## Appeal Decision

**Appeal Ref: APP/R4408/D/22/3292715**

**3 Colster Close, Gawber, Barnsley S75 2LR**

- The appeal is made under section 78 of the Town and Country Planning Act 1990 against a refusal to grant planning permission.
  - The appeal is made by Mr Brazier against the decision of Barnsley Metropolitan Borough Council.
  - The application Ref 2021/1108, dated 12 August 2021, was refused by notice dated 24 November 2021.
  - The development proposed is erection of extension to eaves and roof height of dwelling to create attic bedroom within the roofspace and provision of associated rooflights.
-

FRONT ELEVATION AS PROPOSED

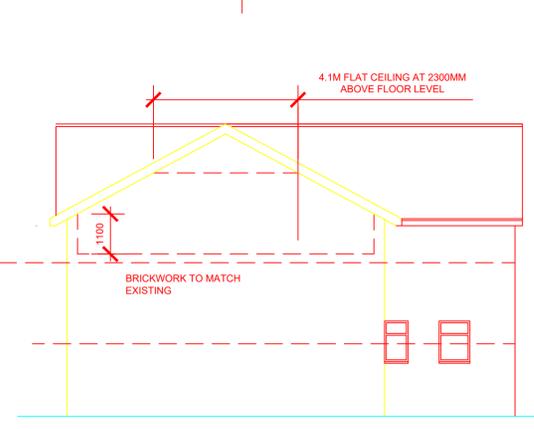
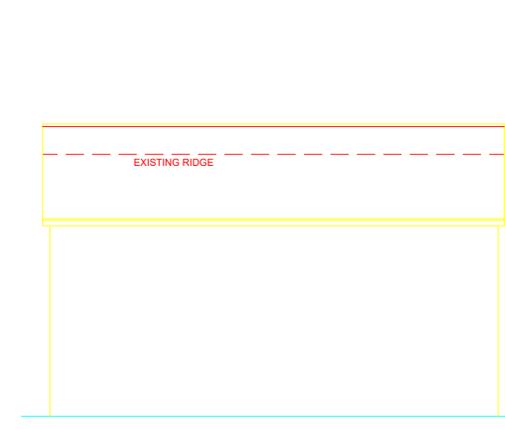
4. The property subject to the appeal is two storeys in height, with an attached garage that is built over to give additional living space. It is built in brick, but with stone facing to the front elevation. The area is residential in nature, but the immediate locality is made up of predominately single storey dwellings, making the appeal property appear unusual in its surroundings.
5. The proposal would see an extension to the eaves above the garage in order to create additional roof in the roofspace to form another bedroom. This would raise the height of this section of the property above the ridge of the main dwelling, so to compensate, it is proposed to raise the ridge of the main dwelling by approximately 900mm. This would amend the pitch of the roof accordingly.

6. I find that the alteration of the roof height to the main dwelling, and subsequent change of the roof pitch, would make the property look incongruous in the area. At present, being the only two-storey property in the immediate locality, it has the outward impression of dominating its surroundings, which would be further magnified by the raising of the roof height and roof pitch.

7. Whilst it may not cause any additional harm to adjacent single-storey dwellings by overshadowing, the works involved in the creation of the proposal would accentuate its dominating position as the only two-storey dwelling in the immediate locality, focussing attention on its incongruity within the area and would create a negative aspect to the character and appearance of the area

8. As a result, I find that the proposal would cause harm to the character and appearance of the area, by means of the roof height increase, and the subsequent change to the roof pitch, which would be contrary to policy D1 of the Barnsley Local Plan (2019) that amongst other matters, expects development to be of high-quality design and be of an acceptable scale, form and proportions.
